**WEST SUSSEX COUNTY COUNCIL
STRATEGIC PLANNING CONSULTATION**

SUBJECT: A/142/14/PL- Redevelopment of site for small Class B1 (Business, Light industry) and B8 (Storage or distribution) industrial units. Departure from the Development Plan.

Old Barn Nursery, Dappers Lane, Angmering, West Sussex, BN16 4EN

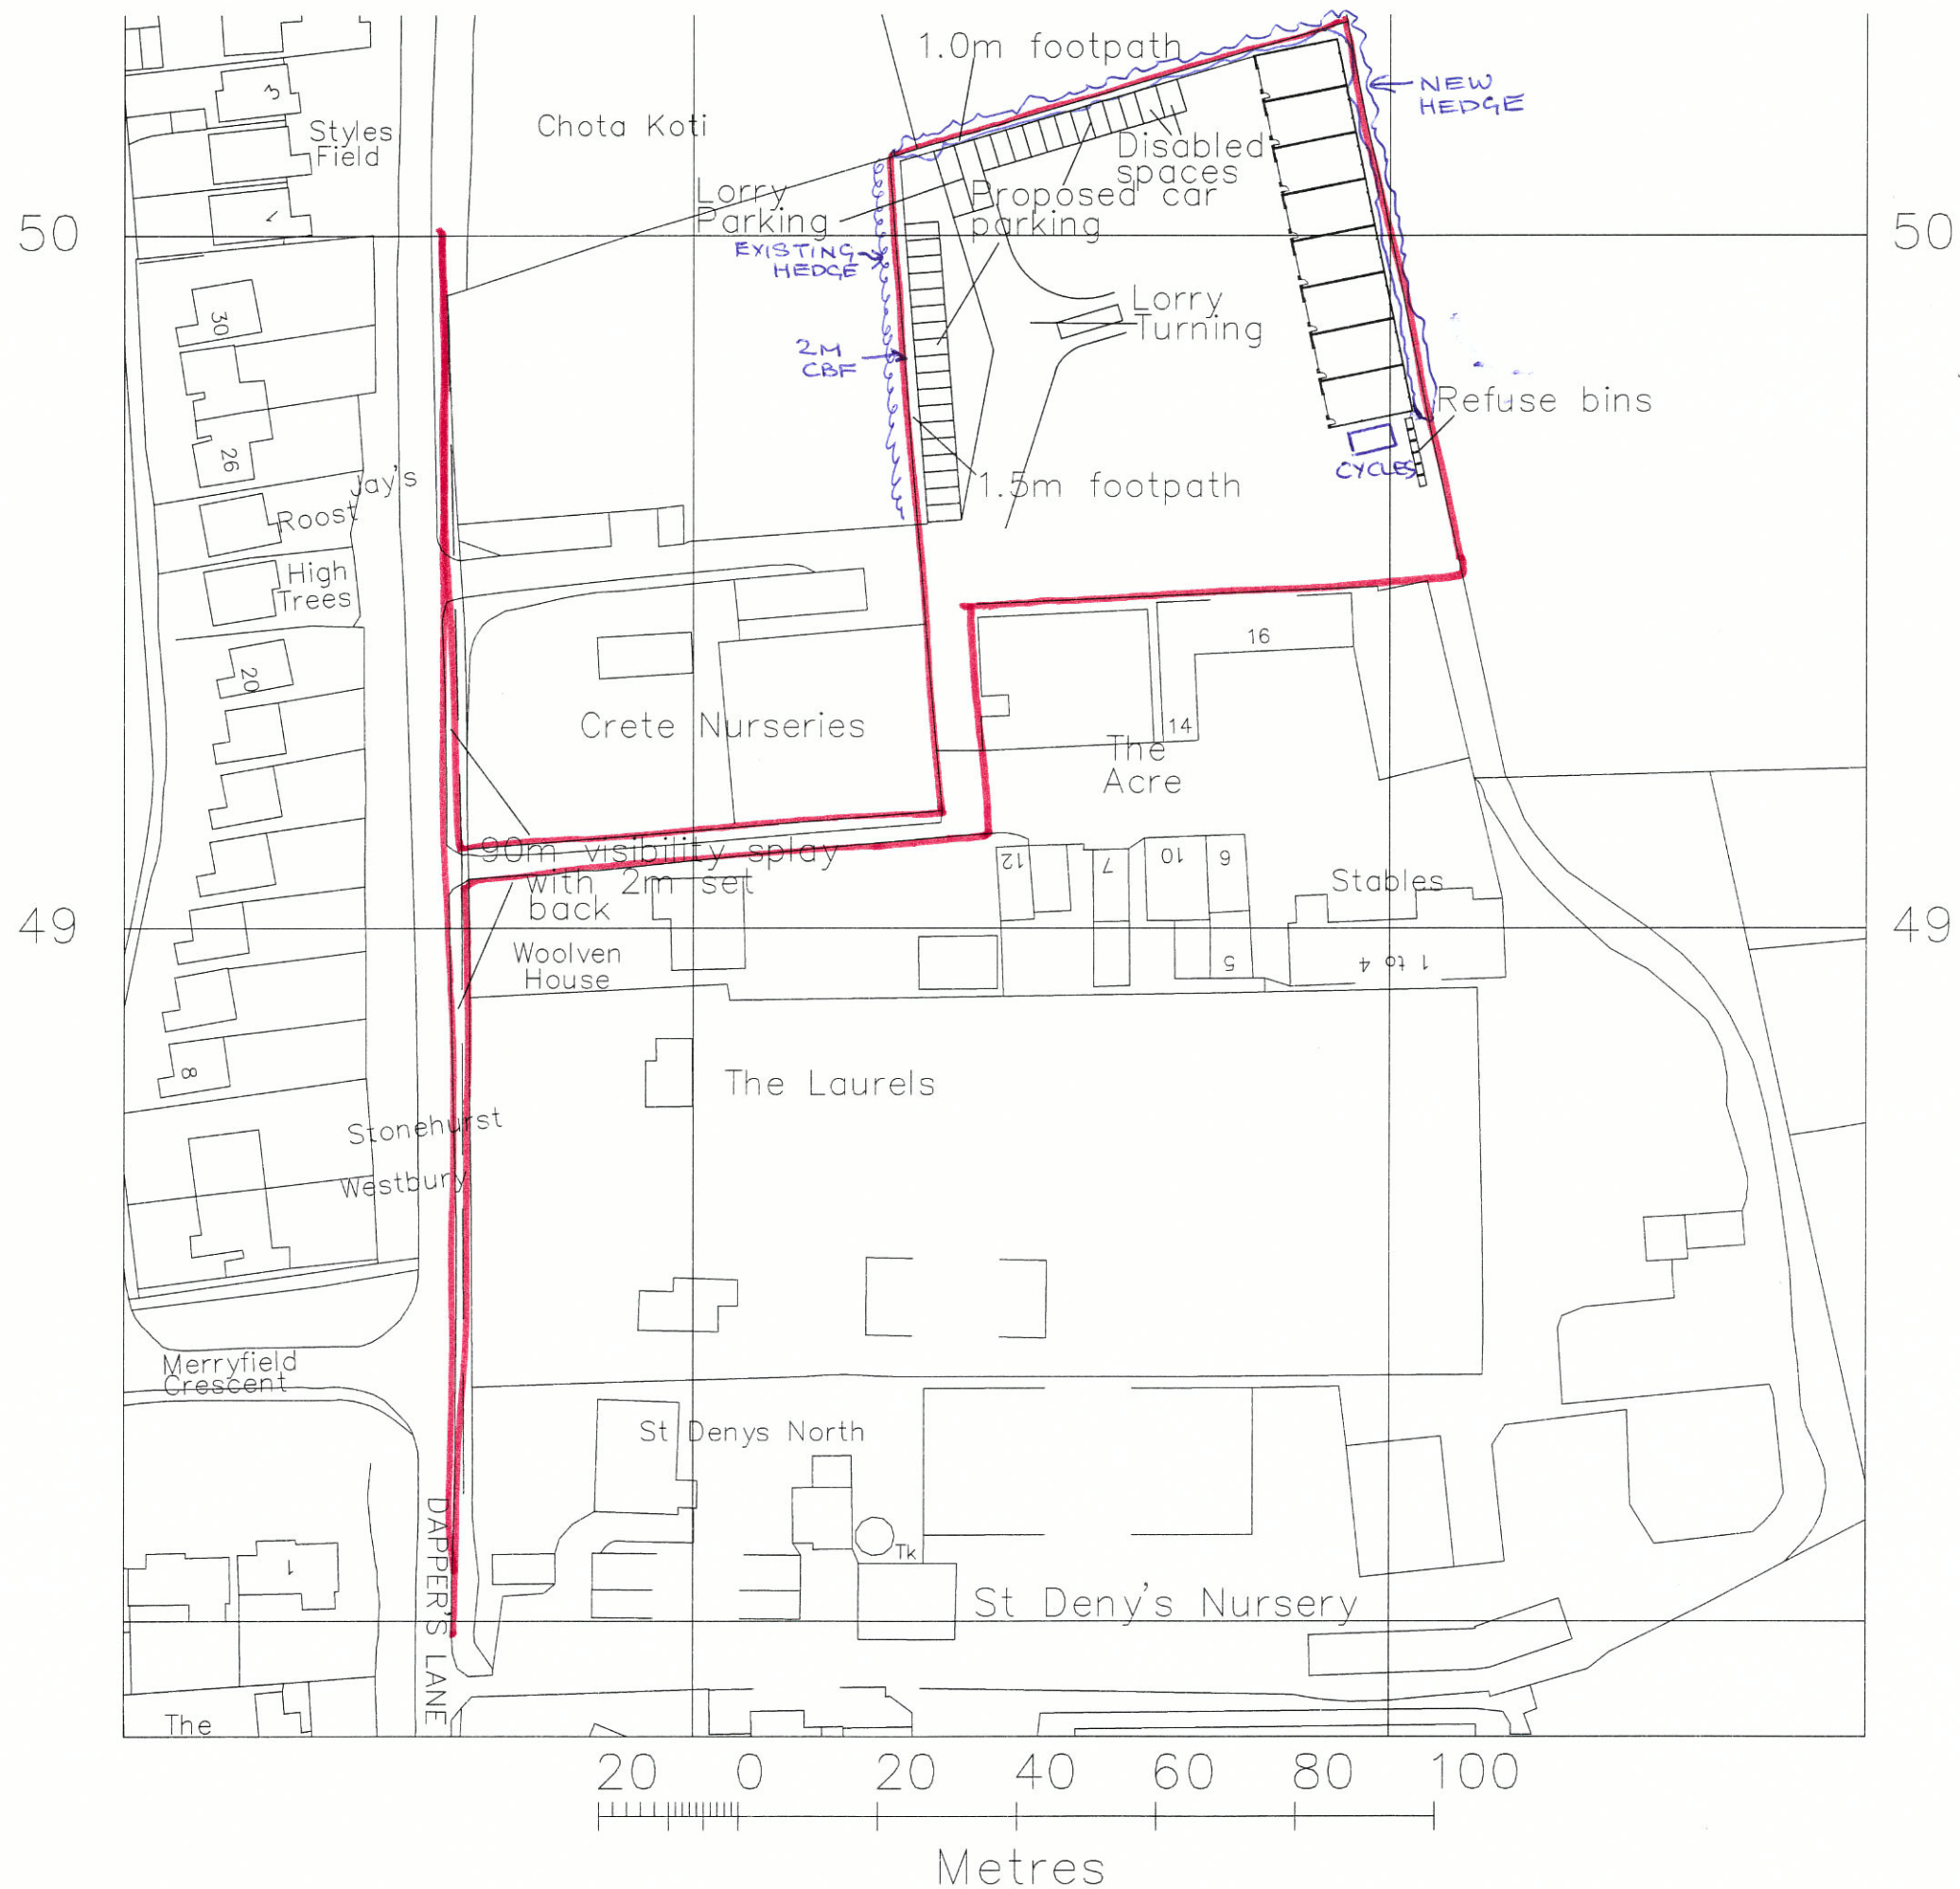
Vehicular access to the site is possible only from Dappers Lane. No changes are proposed to the existing access arrangements. The site has an access road which is not part of the

adopted highway and has an initial width of approximately 5.5 metres, narrowing down to 4.8 metres. From the red edge shown on the site plan it would appear that the applicant has control of a proportion the land to the south of the site, I would therefore advise that a large proportion of the existing hedgerow is cut back and maintained to achieve an adequate visibility splay.

Within six months of the date of this planning consent, maximum visibility splays shall be provided at the site access onto Dappers Lane in accordance with a plan to be submitted to and approved by the planning authority. These splays shall thereafter be kept clear of all obstructions to visibility above a height of one metre above the adjoining road level.
